## Letter of Observation:

Priorsland SHD, as described at <https://www.priorslandshd.ie/>

**Ref: ABP-313322-22**

“Development within the Cherrywood Strategic Development Zone (SDZ) subject to the Cherrywood Planning Scheme, 2014 (as amended). The development will comprise a mixed use Village Centre and residential development of 402 no. apartments”.

Plot D: Ground Floor Plan

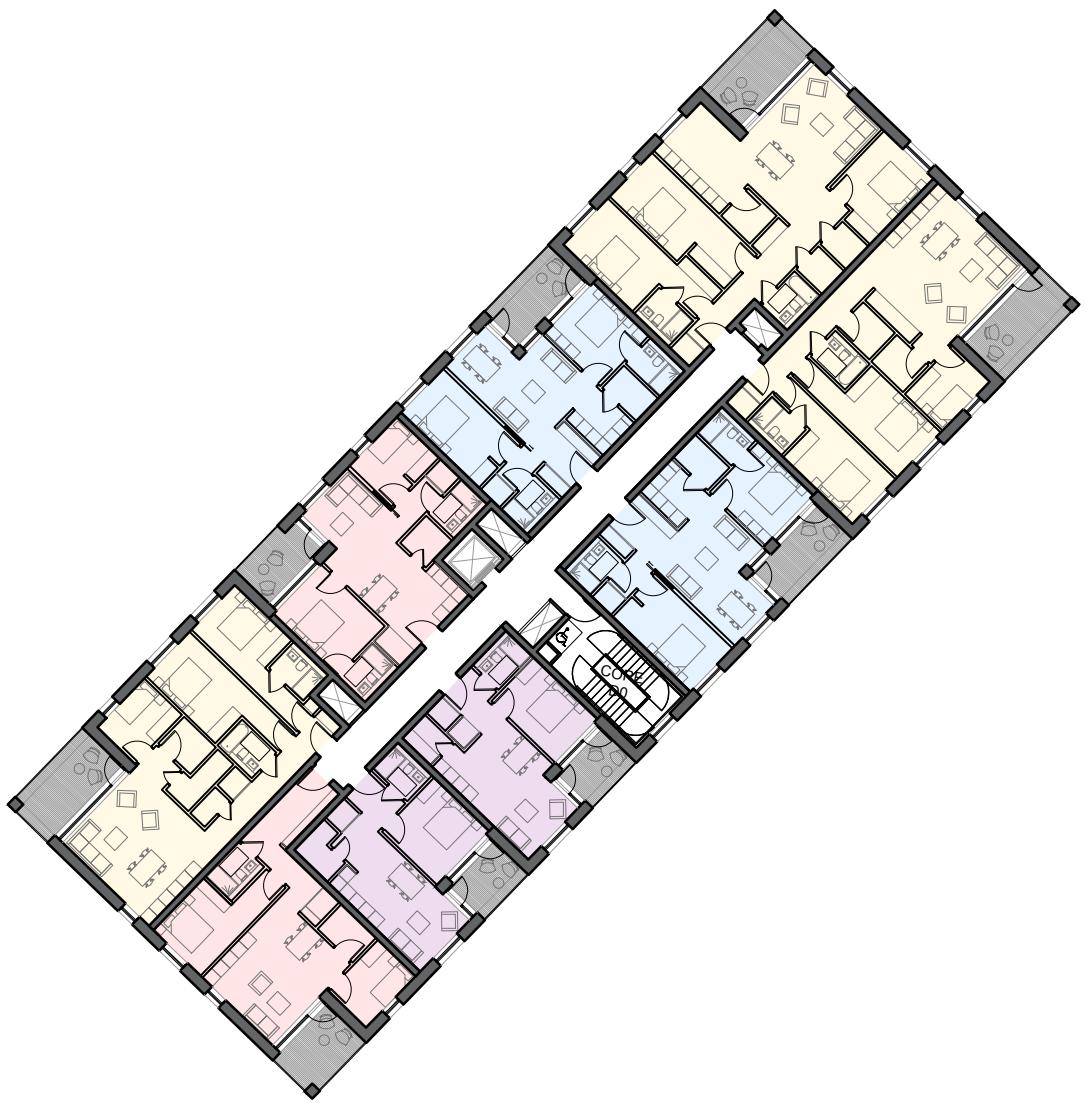
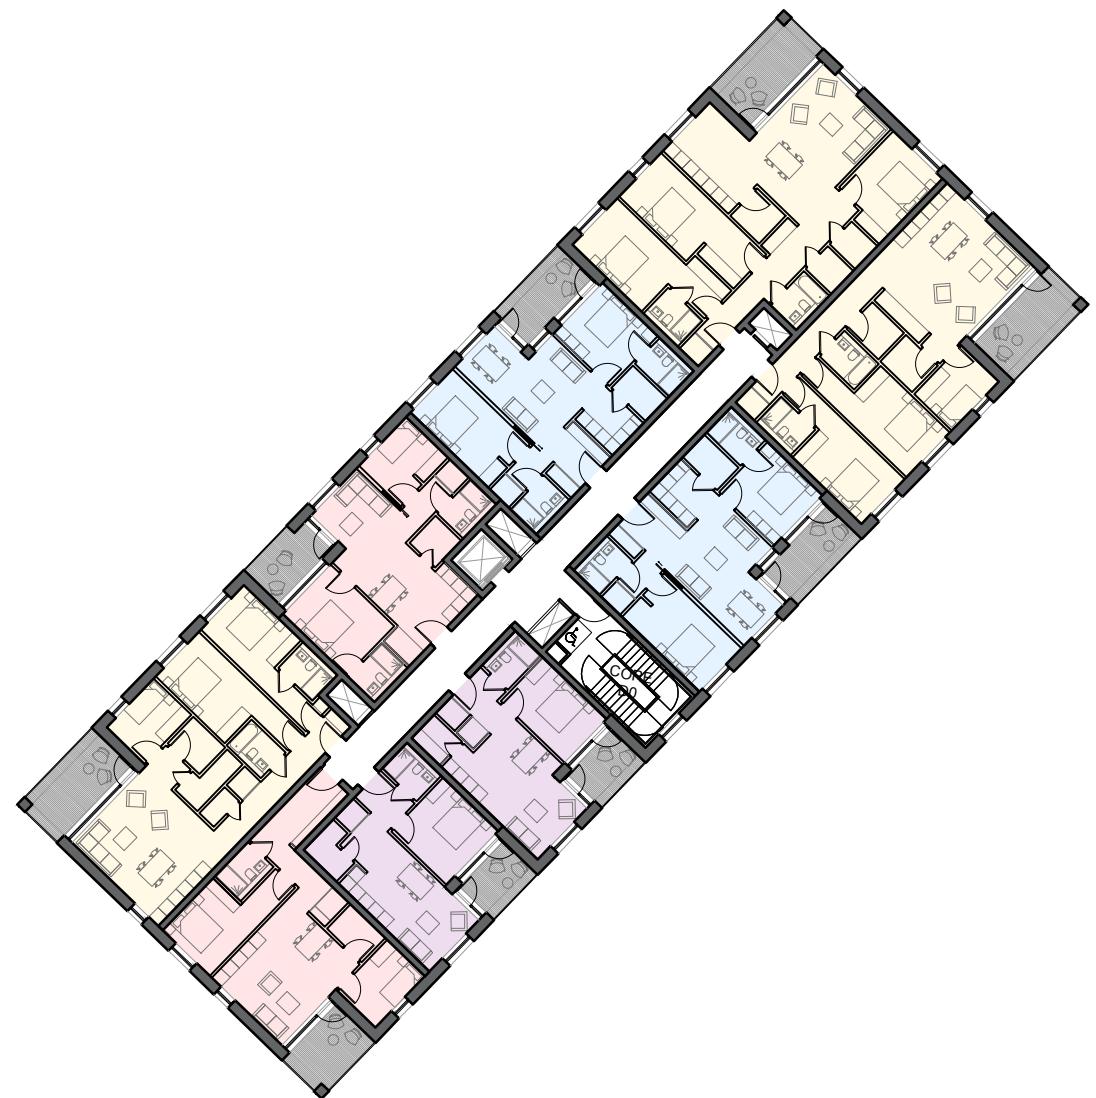
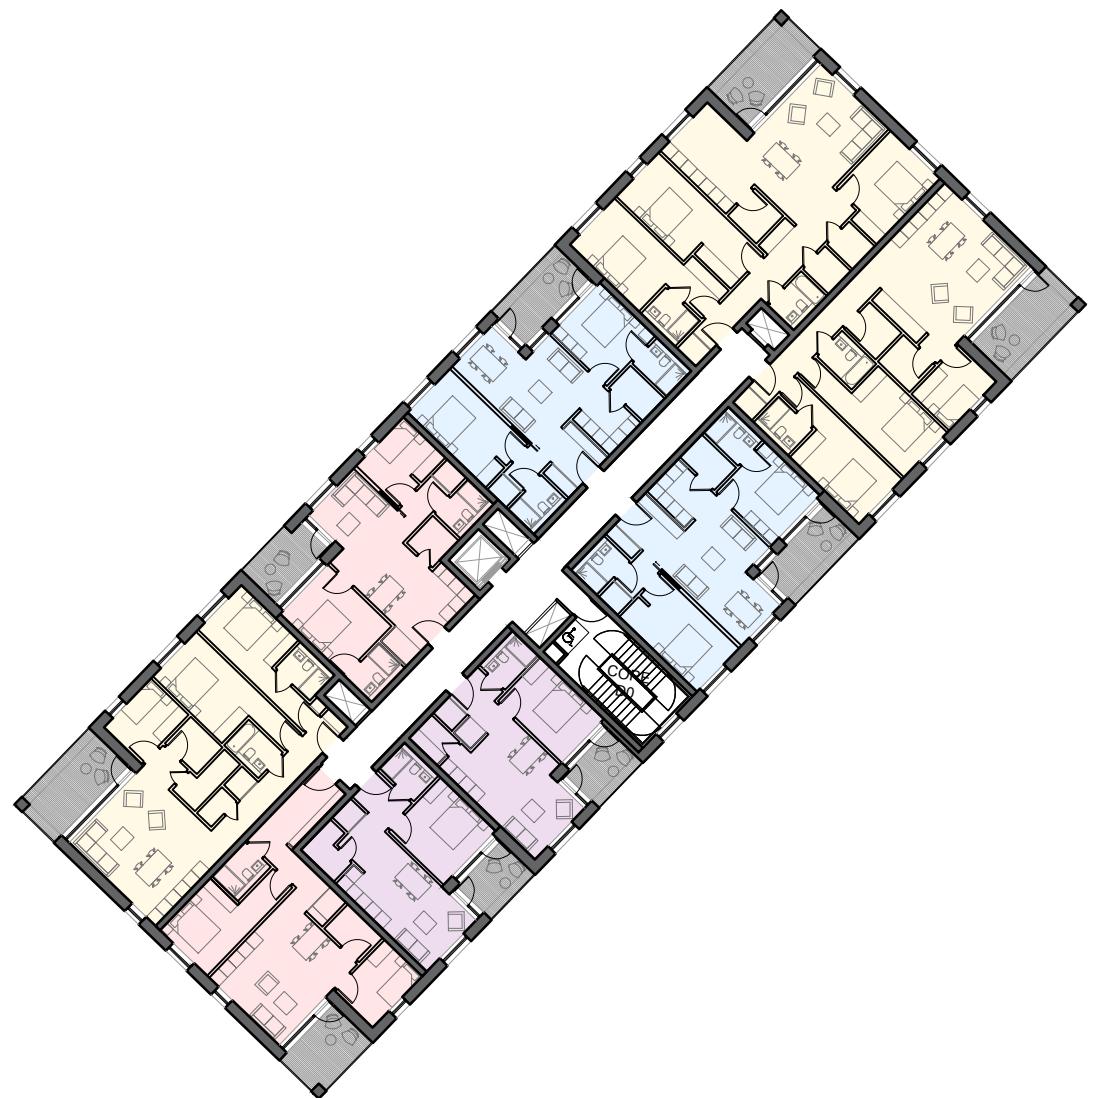
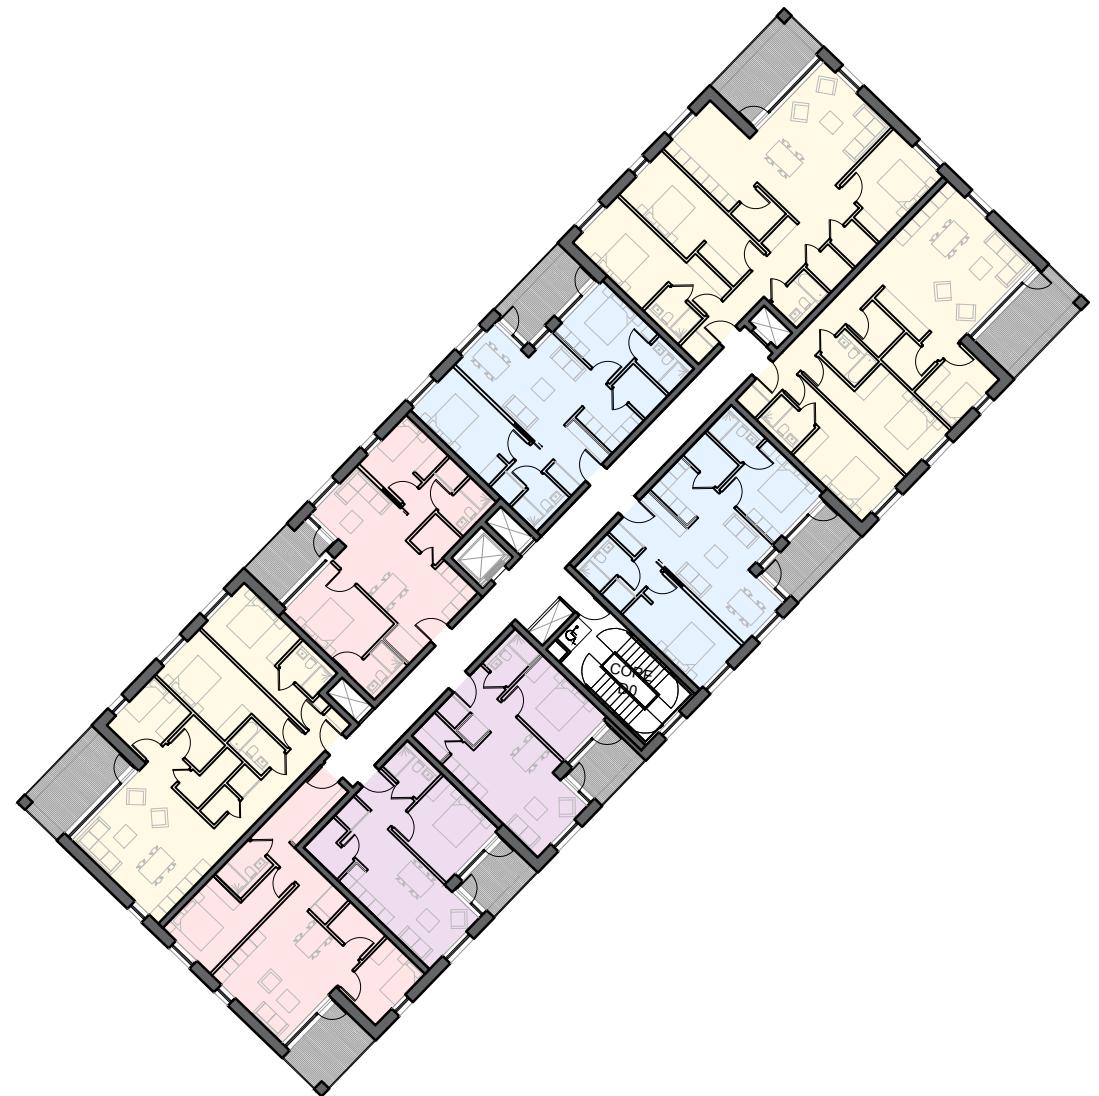
1. All of the Part V units are located in a single block, Block D, thereby isolating those occupants from routine inclusion within the full breadth of the community of occupants of this development
2. Location of this Block D and all of these Part V units is concentrated in the most disadvantaged portion of this development site in terms of:
  - Distance from the Village Centre
  - Distance from the Luas stations
3. Mix of Part V housing units is not reflective of the mix of units throughout the application, resulting in the exclusion of those on the housing list who need a larger housing unit, as included in this application.

1. Allocate the relevant number of Part V housing units across all of the development's apartment blocks and houses in a manner that is fully inclusive within the community of occupants of the development
2. Adjust the mix of units to that it provides for the appropriate number of 3-bed houses, 4-bed houses, 1-bed apartments, 2-bed apartments and 3-bed apartments so as to widen the availability of the housing units to the full range of housing applicants.

In this specific SHD application, I suggest a mix such as:

- 15 1-bed apartments
- 22 2-bed apartments
- 4 3-bed apartments
- 2 3-bed houses
- 2 4-bed houses
